From: Clarke (Heba & Brian) [REDACTED]
Sent: 12 September 2019 09:26
To: Simon Davis
Subject: Subject: AW/237/19/PL Former Ship Inn

As we live close to the former Ship Inn I am writing to express my **total objection** to the above application.

Title
Site Location Plan with Vehicle Tracking : Articulated Vehicle

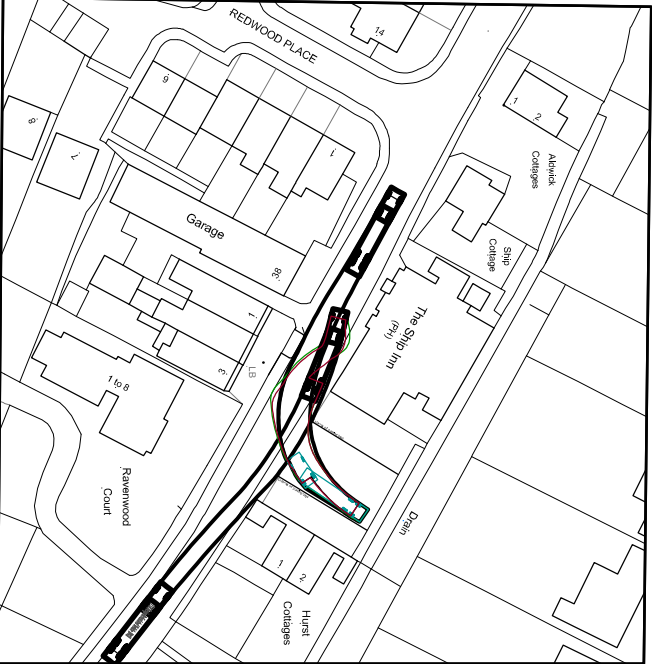
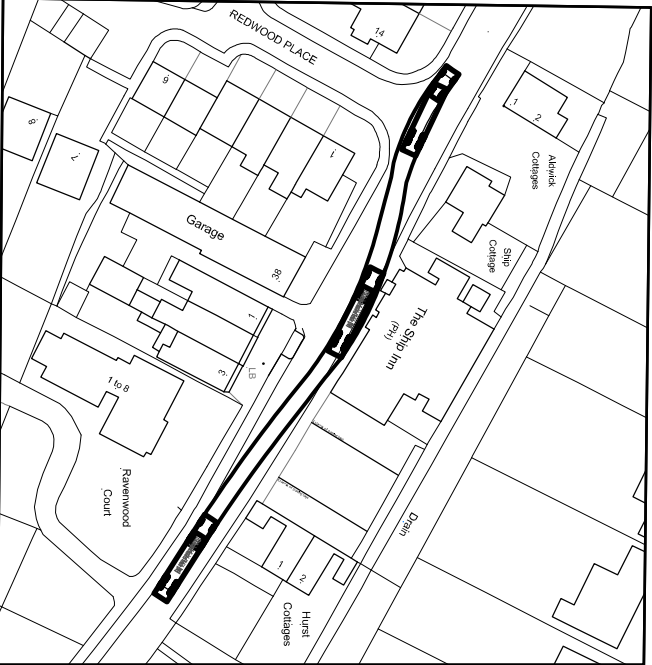
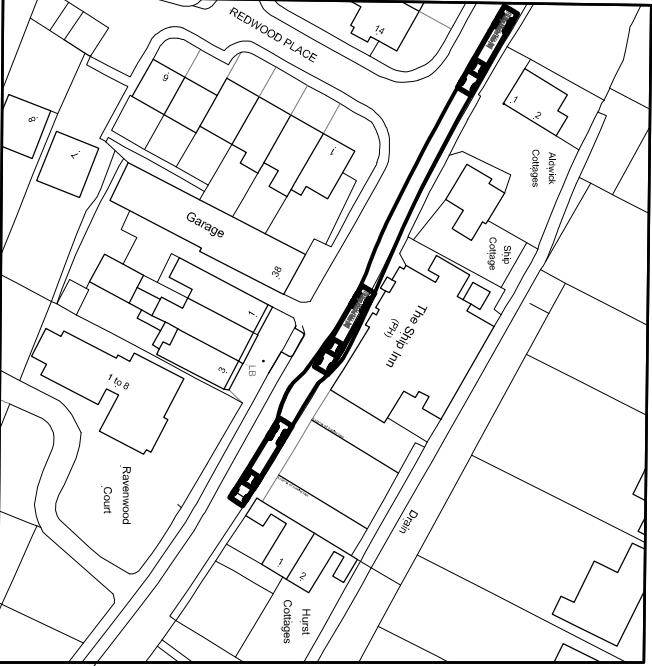
You should be aware that this is a narrow, busy street, the car park has capacity for very few cars, therefore shoppers would resort to parking in the road outside the site, causing traffic disruption and safety concerns. Pedestrian access to the site is limited so with cars parked in the road there would be further risks to pedestrian health and safety.

I have looked at the delivery schedule/arrangements and it is clear that these will be a considerable nuisance to us the local people.

How can a 38ft, 28 tonne articulated truck be able to negotiate deliveries without serious health and safety issues, 4 times a week. Add to this the 4 deliveries by 3.5 Tonne box van, 3 deliveries by 18 Tonne rigid vehicles, 5 deliveries by 26 Tonne refrigerated vehicles, 12 deliveries by 18 Tonne rigid vehicles and 7 transit vans each week and I'm sure you'll agree that things would be very miserable for local residents. Our road to and from other areas will be blocked as well

There health, safety and well being will be considerably challenged. Its also worth noting that the estimated 35 delivery slots per week is considerably greater than the three deliveries a day (21 per week) that Morrison's had permission for and caused enough disruption at the time.
